**Application by Highways England for a Development Consent Order in relation to the A585 Windy Harbour to Skippool Improvement Scheme (TR010035)**

Fylde Borough Council (our reference: 20021788)

17 May 2019

**Deadline 2: Written Representation (FBC document reference 2.1)**

Project A585 WINDY HARBOUR TO SKIPPOOL IMPROVEMENT SCHEME  
Drawing Title ENVIRONMENTAL MASTERPLAN SHEET 5 OF 32

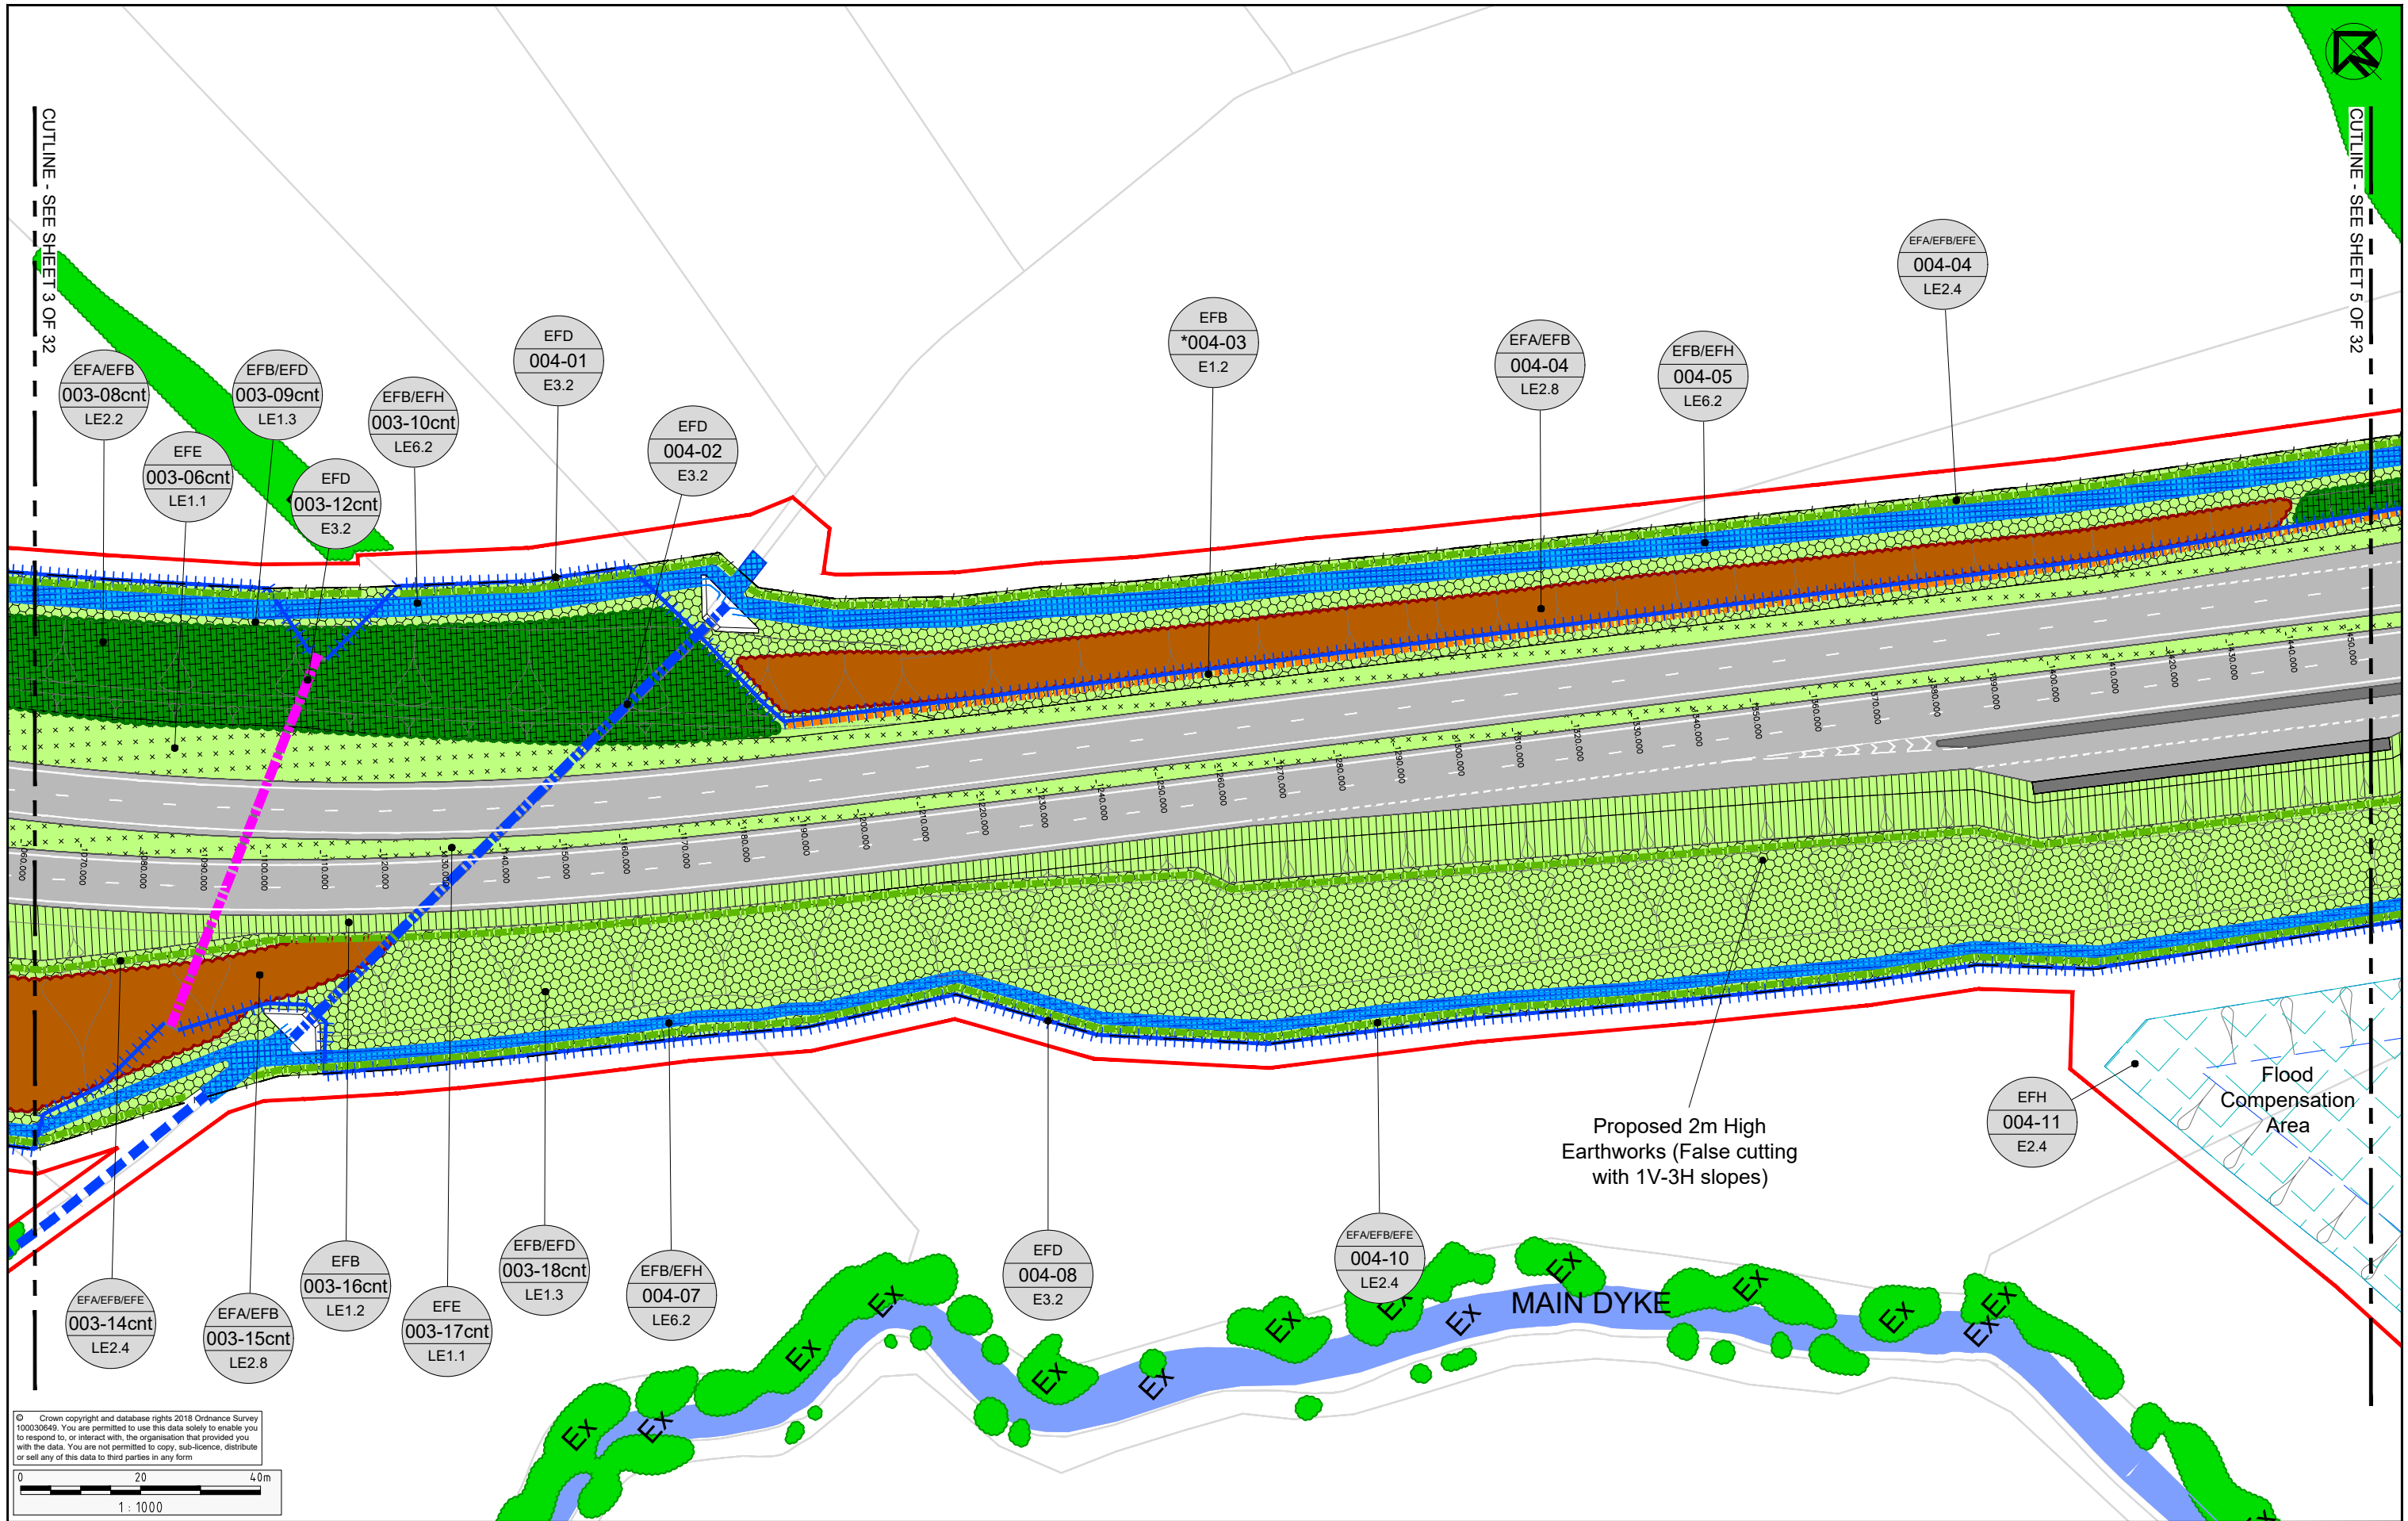
- A 2m high noise barrier is proposed to the east of the Lodge Lane bridge, along the southern edge of the bypass where it flanks Barnfield Manor and The Manor. This noise barrier is shown as an acoustic fence backed by low-level planting on viewpoint 10 of document 6.9 to the ES. The LPA considers that it would be preferable for this fence to be replaced with an alternative boundary treatment (e.g. a red brick wall) in order to afford a more sympathetic relationship with the vernacular of neighbouring buildings.
